Please see below a table with the key issues outlined and responses from the applicant to these responses, I trust that all outstanding issues are now resolved and the application can be sent to the next available planning committee.

Outstanding Queries/Issues to be Resolved and Responses

Drawing Title
**EXTERNAL WORKS
SHEET 2**

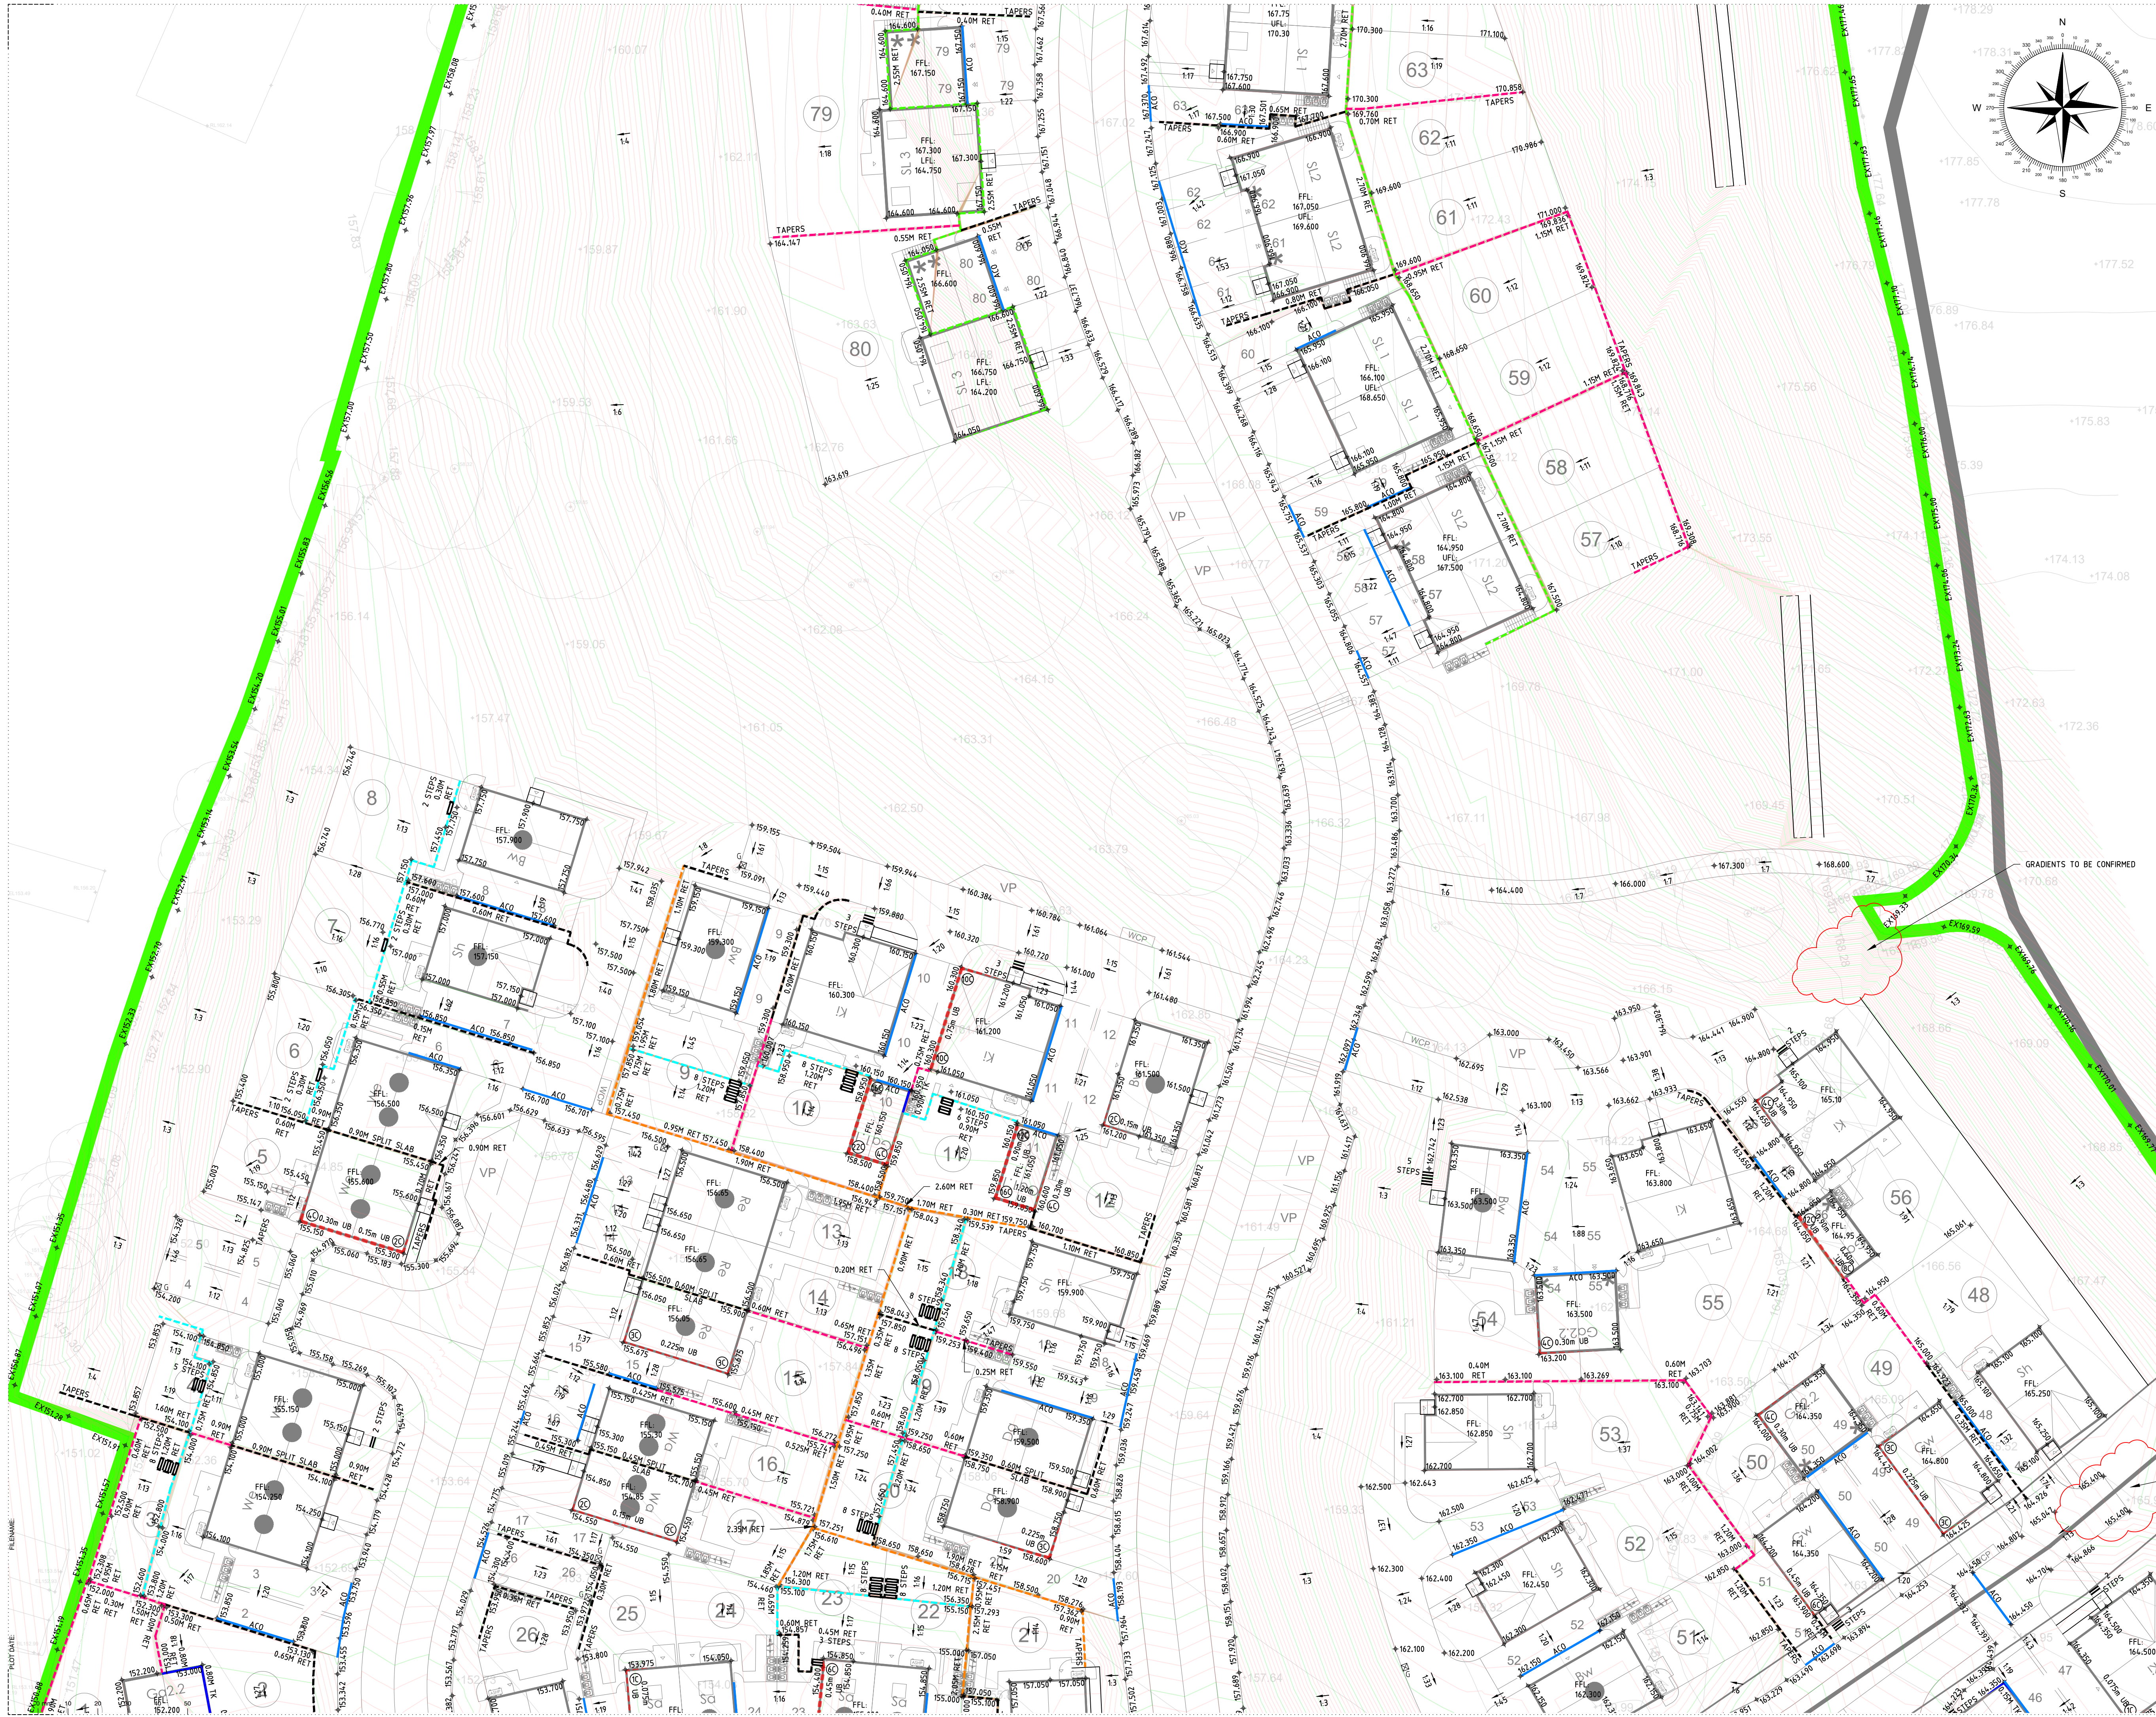
Rear Garden Gradients Most of the rear garden plots have a gradient of 1:10, however plots 27, 29, 33, 39, 55, 56, 65 and 66 are labelled as 1:13 to 1:27 with the gardens of plots 30 and 31 split in the centre with a gradient 1:10 each part ? This raises some concerns over the usability of the spaces and result in	Revisions have been made to rear garden gradients across the Salesbury View site and the site is now compliant with NHBC standards, with maximum gradients no steeper than 1:6. This includes the addition of retaining walls and some minor tweaks to the layout to accommodate this such as the relocation of bin stores and of Air Source Heat Pumps.	External Works Sheet 1 (210687-EDGE-XX-XX-DR-C-1001_EXTERNAL WORKS SHEET 1[P03]) External Works Sheet 2 (210687-EDGE-XX-XX-DR-C-1002_EXTERNAL WORKS SHEET 2[P03])

retaining structures within or at the end of the plots we are particular concerns about impacts along the southern boundary to the protected woodland. I could not see that the previous proposal had gradients such as these proposed?		External Works Sheet 3 (210687-EDGE-XX-XX-DR-C-1003_EXTERNAL WORKS SHEET 3[P01]) External Works Sheet 4 (210687-EDGE-XX-XX-DR-C-1004_EXTERNAL WORKS SHEET 4[P01]) External Works Sheet 5 (210687-EDGE-XX-XX-DR-C-1005_EXTERNAL WORKS SHEET 5[P01]) Edge Retaining Wall Typical Sections (210687-EDG-XX-XX-SK-S-000001 EDGE RETAINING WALL TYPICAL SECTIONS [P02])
Visitor parking The proposed 11 visitor parking spaces were not requested by us or highways is this a result of third-party comments? They do seem to be rather sporadic around the site, and I presume these would be monitored and maintained by a third party. Just wondering if these are necessary or could be better sited in clustered closer to each group of properties to make them more useable?	The previous submission included 11 visitor parking spaces to avoid any degradation of the planning application; these have been carried over to this application. These spaces ensure that visitors do not put pressure on the existing and proposed highway network by having dedicated visitor parking within the development. These have been spread out across the development rather than grouped to encourage their use. For example, if the spaces were grouped together at the south of the site visitors to the north would be unlikely to use them and vice versa. Monitoring would be carried out by the resident owned management company.	Proposed Site Layout (Ref 101 P27) Transport Assessment (Rev 08)

- The swale has been moved so that it does not interfere with the PROW or woodland.
- Rear garden gradients to ensure compliance with NHBC standards, with maximum gradients no steeper than 1:6.
